241–244 PENNANT HILLS ROAD, CARLINGFORD

RTS MATRIX – KAA RESPONSE

MAY 26, 2026

This report has been prepared by Kennedy Associates Architects to address and respond to the urban design and architectural issues set out in the DPHI Letters of 5 & 26 February 2026 and Parramatta City Council submission dated 3 February 2026 for the proposed development at 241-244 Pennant Hills Road, Carlingford – SSDA No 84699461.

Figure 2 Council bin collection points

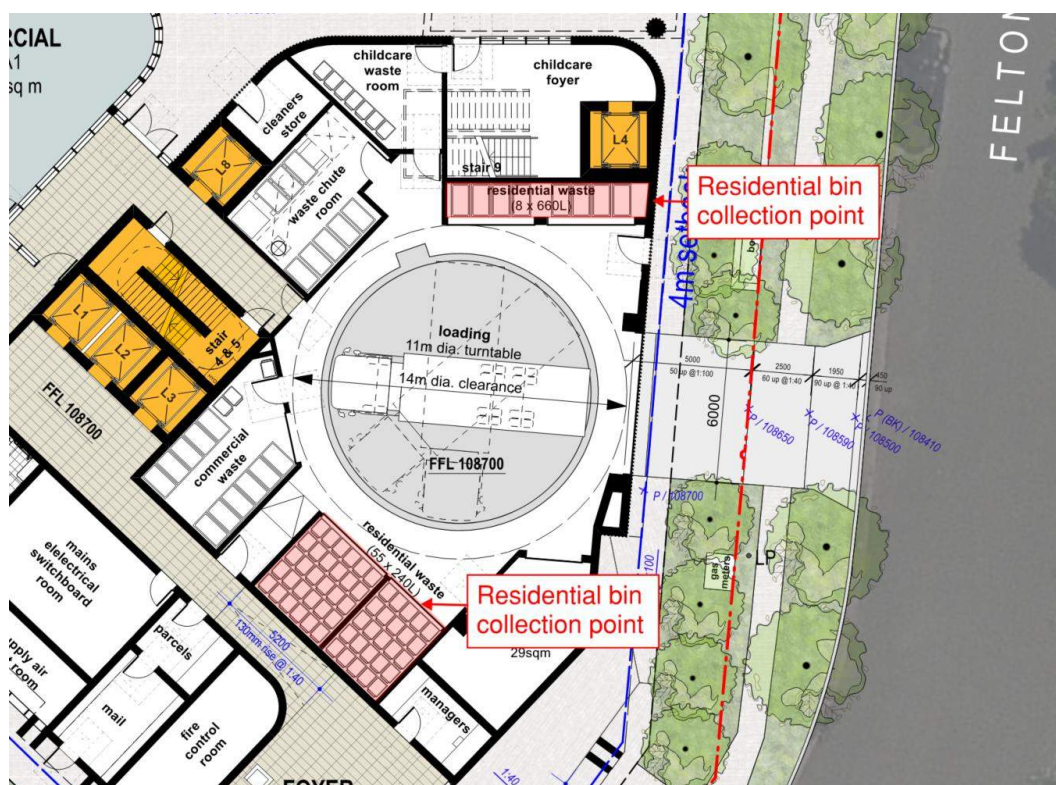
Ref	Agency	Comment	KAA Comments
Parramatta City Council Submission – Cover Letter			
C-1	CoPC	Waste Collection The proposed ground floor loading dock cannot accommodate Council's waste collection vehicles and Council will therefore be unable to service the residential component of the development. Council can provide further information on our requirements.	The loading bay is specifically designed to accommodate Council's waste trucks. It: - includes an 11m dia. turntable with a 14m dia. clearance zone - has a 4.5m floor to ceiling height in accordance with AS 2890.2 Traffic Swept Path Analysis have been updated to demonstrate capacity for the site to be serviced by Council's HRV rear loader waster vehicle which is 10.7m long x 3.8m high  Figure C-1.1: Loading dock swept path analysis of Council's HRV waste truck

Residential Buildings B & C Waste Transfer Pathways

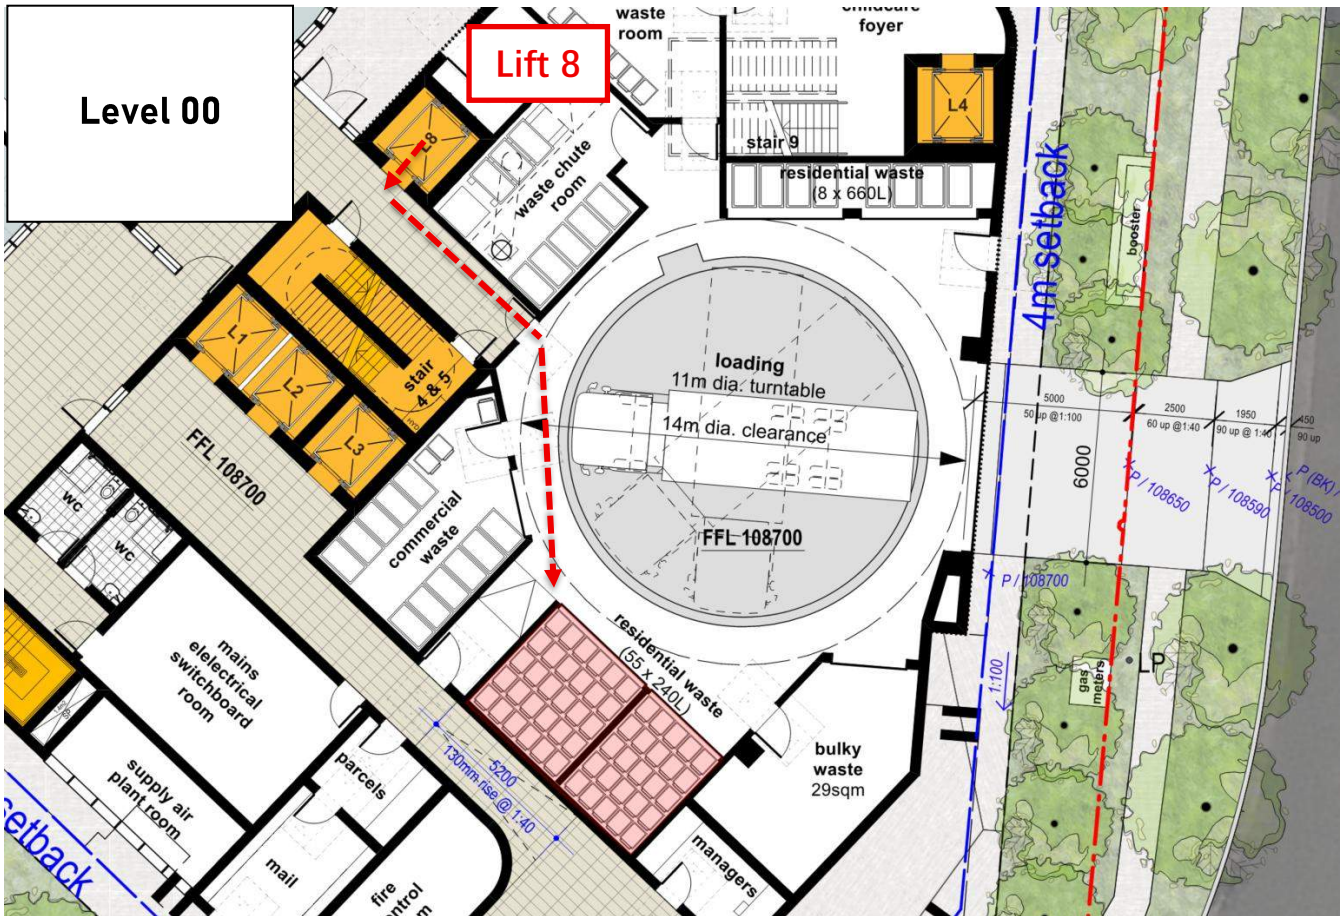
4b	DPHI	The proposed waste management arrangements indicate that building manager/caretaker is responsible for moving the waste bins from Buildings B and C on the western side of the site to the collection area in Building A. Appendix B of the WMP indicates the path of travel for commercial via the pedestrian site link/ central forecourt, however the WMP does not indicate: - residential movements from Buildings B and C on the western side of the site to the collection area in Building A. - what time of day these movements from Buildings B and C on the western side of the site to the collection area in Building A will occur, nor the frequency. The number of movements of bins through the central forecourt should be limited, as well as the time of day, to ensure that it occurs at a suitable time where there will be minimal pedestrian conflict whilst adhering the noise management measures.	Within Buildings B & C, each commercial tenancy is provided with its own bin storage area whilst residential units are provided with bin rooms on each level. The movement of bins to the bin collection area will be done by Building Management. The design has been amended to enable commercial and residential waste in Buildings B and C to be taken down to Basement Level 1 (via Lifts 5, 6 and 7) and then taken across to Lift 8 and carried up to the waste and loading areas on the ground level of Building A. A bin tug storage location has been provided in Basement Level 1. Figure 4-b.1: BLD B commercial waste carting route to Lift 5 Figure 4-b.2: BLD C commercial waste carting route to Lifts 6&7

Figure 4-b.3: Building B & C waste bin carting route in Basement 1
